**Our ref:** XA/2025/100491/02-L01  
**Your ref:** EN020026  
**Date:** 16 February 2026

**Sea Link Issue Specific Hearing 2 supplementary questions**

ISH2.028.	Limit to deviation for Fromus Bridge	Applicant/relevant planning authorities	Provide suggested wording for adding this to article 5 of the dDCO.
-----------	--------------------------------------	---	---

SAXMUNDHAM SECTION C-C

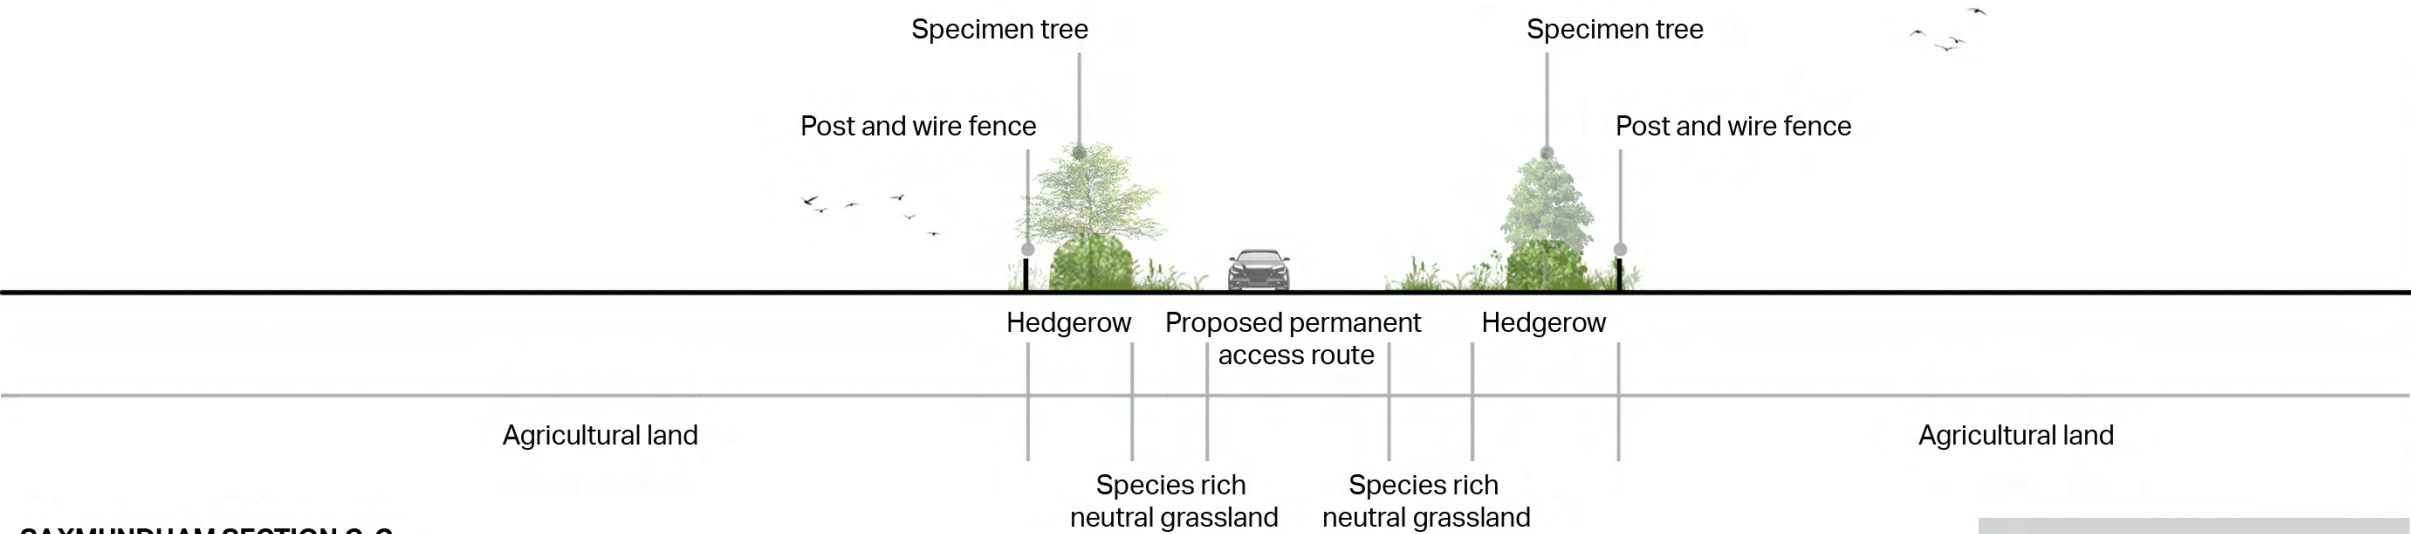
this would take away our ability to ensure the mitigations proposed are appropriate at a highly sensitive WFD waterbody (the Fromus River). We would require the applicant to consult us (The Environment Agency) with their riparian planting plans and seek our approval.

We suggest the following wording:

5. (d) In respect to the work no.3a, specifically the bridge proposed over the river Fromus, deviate in regards to the following:
  - (i) the soffit level not extending below 10.49 metres above ordnance datum;
  - (ii) the deck width not extending beyond 6 metres
  - (iii) abutment set back from the River Fromus not retracting beyond 8 metres from the top of the bank.

This wording reflects current discussions on the River Fromus crossing, and a proposed requirement we wish to be input into Schedule 3 Requirements of the DCO. We are currently waiting on our legal department's review of the wording. We will then request that the finalized requirement wording is input into Schedule 3.
